9 July 2021

APPLICATION BY HIGHWAYS ENGLAND (THE “APPLICANT”) FOR AN ORDER GRANTING DEVELOPMENT CONSENT FOR A47/A11 THICKTHORN JUNCTION (TR010037)

APPLICANT’S RESPONSE TO THE SECTION 55 CHECKLIST

Drawing Title: **CROWN LAND PLANS
REGULATION 5(2)(n)
SHEET 6 OF 7**

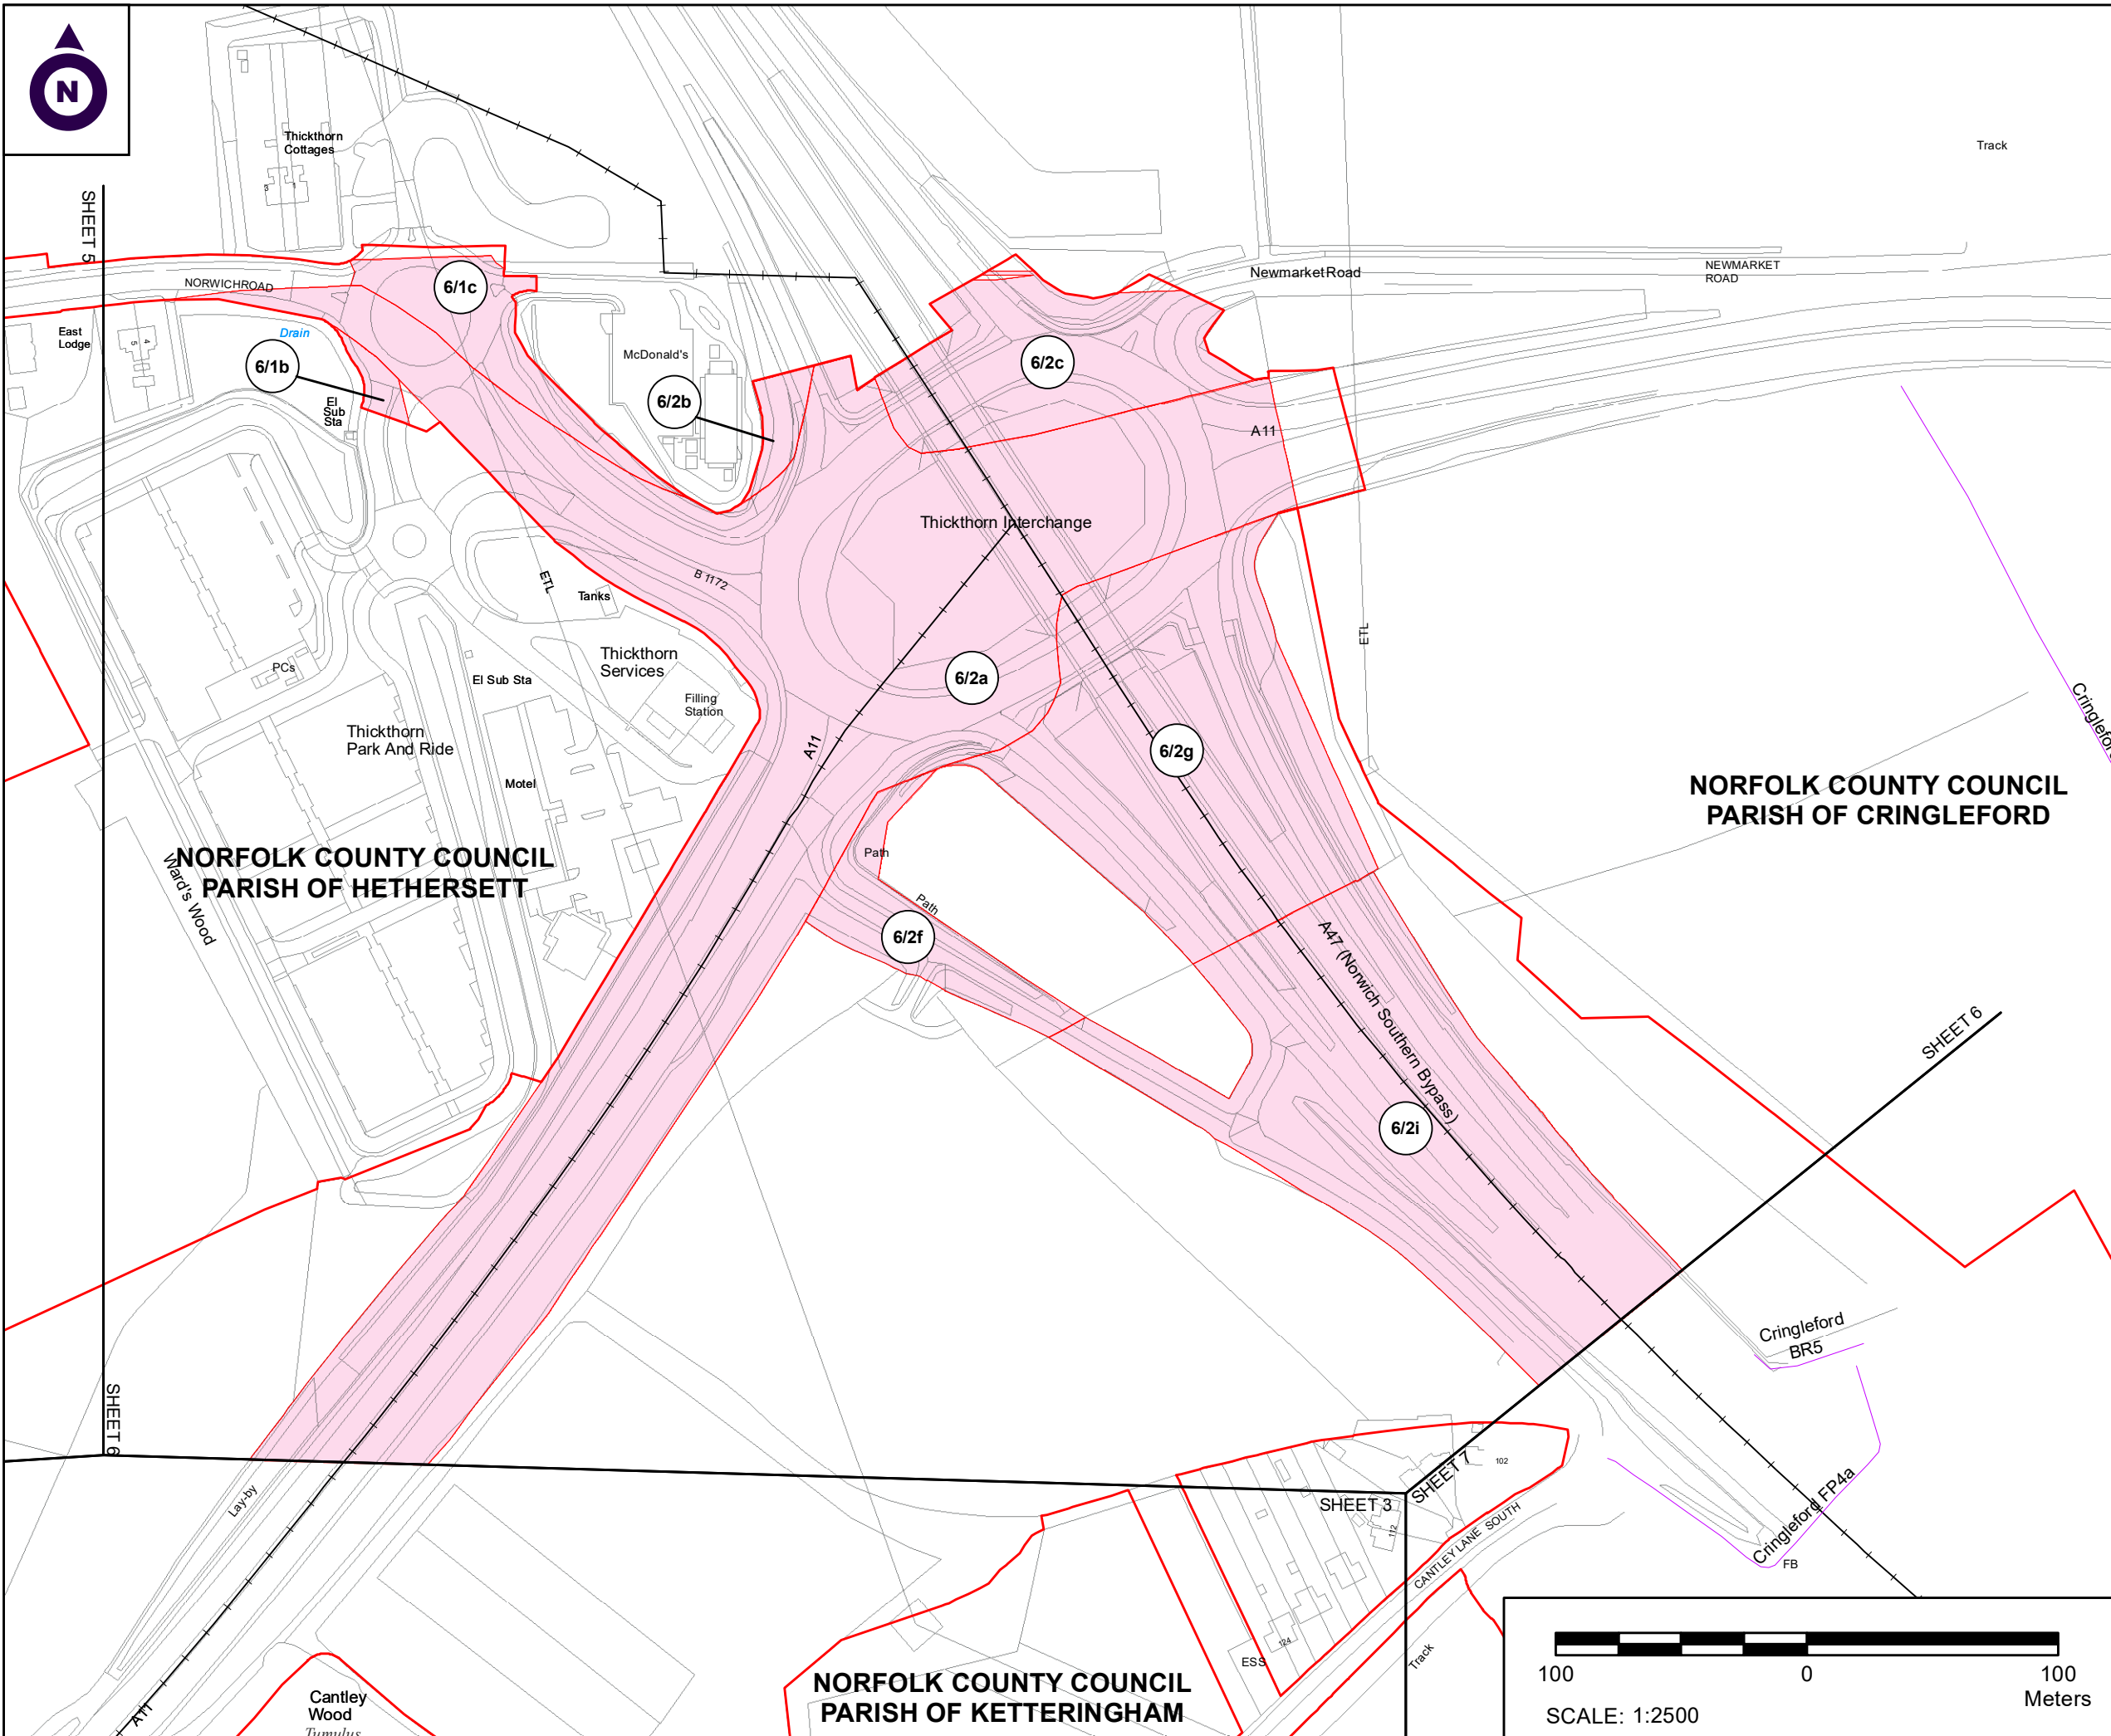
- *Annotations/labels 6/1b and 6/1d do not clearly identify the plots (two short black lines visible in isolation in the middle of the plan)”.*

The Applicant has updated the Crown Land Plans [APP-012] to clarify the annotations/labels in relation to Plot 6/1b and Plot 6/1d. The updated plans are submitted with this covering letter.

Drawing Number: HE551492-GTY-LLO-000-DR-BL-30006	Rev: P04
--	----------

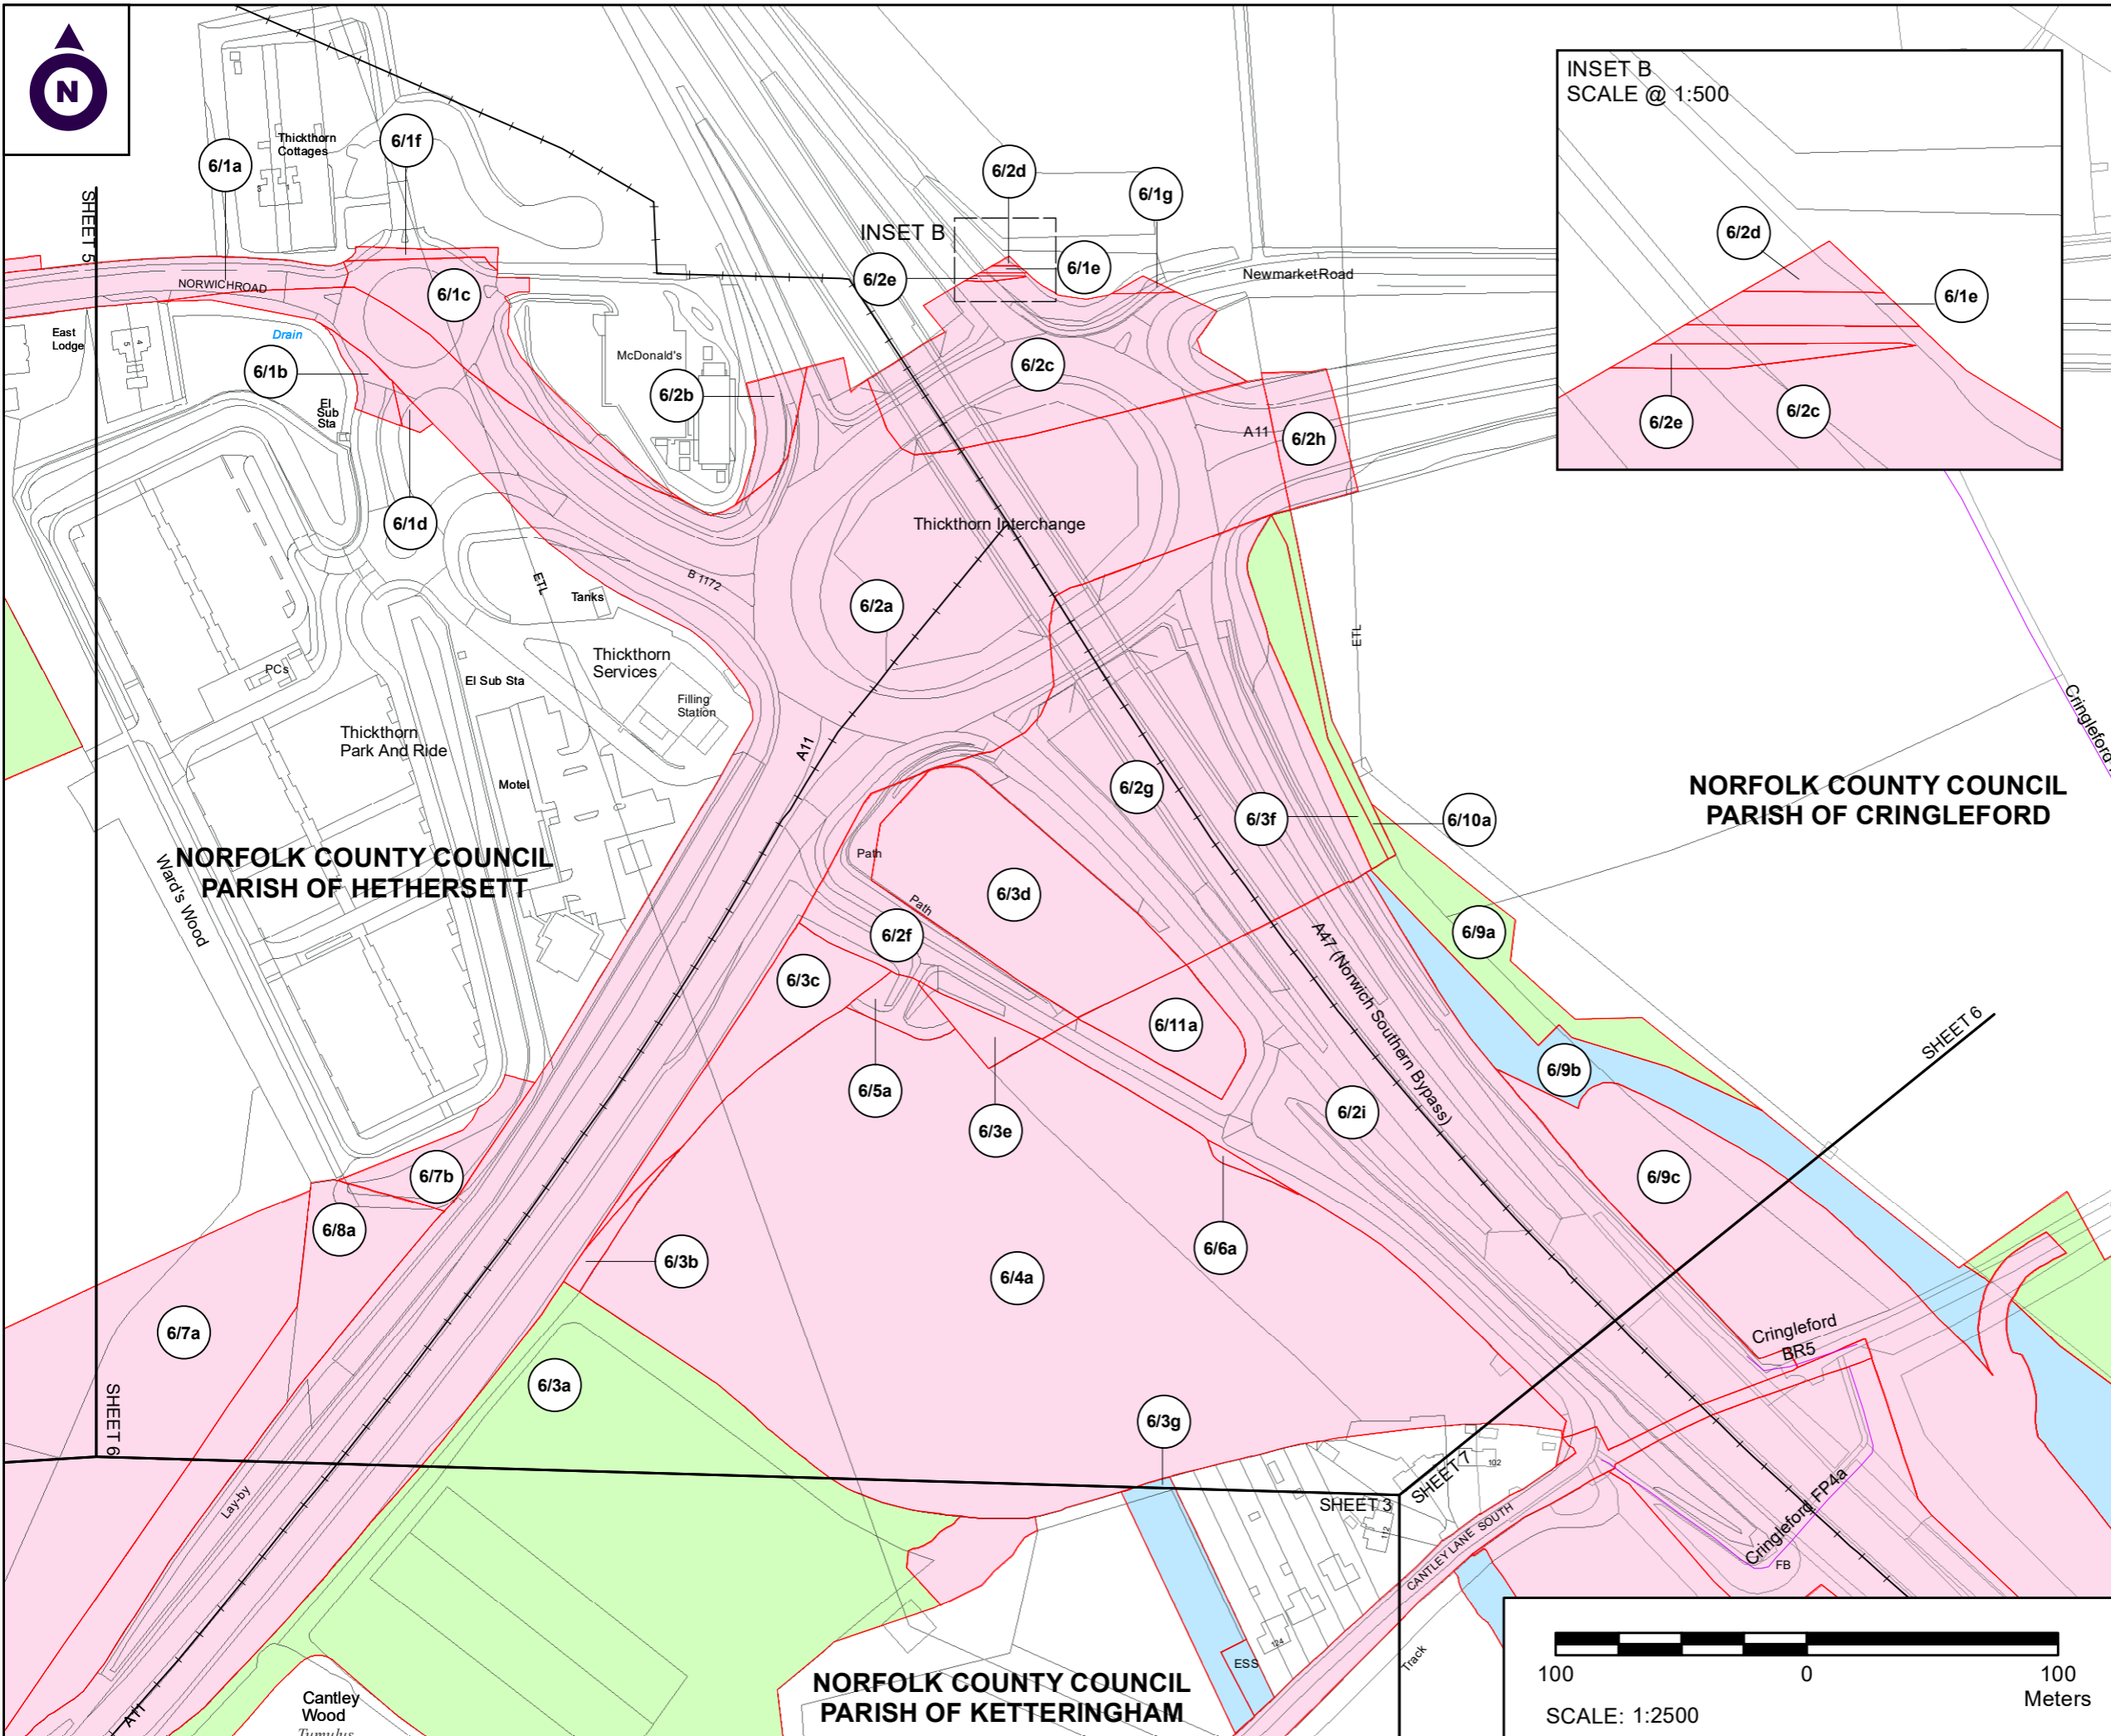
- *The annotations/labels 3/3k and 3/3l do not clearly identify the plots.*
- *Plot 7/1b is coloured pink (permanent possession) however the BoR states the plot is for the temporary possession and use (green).*
- *Plot 7/1c is coloured green (temporary possession) however the BoR describes it as land to be permanently acquired (pink).*
- *The word ‘temporary’ is missing from the legend of Sheet 6 (in relation to the description of plots shaded in green)”.*

The legend on Sheet 6 of the Land Plans [APP-006] has been updated to include the description of “temporarily”. An updated version of the Land Plans is submitted with this covering letter.
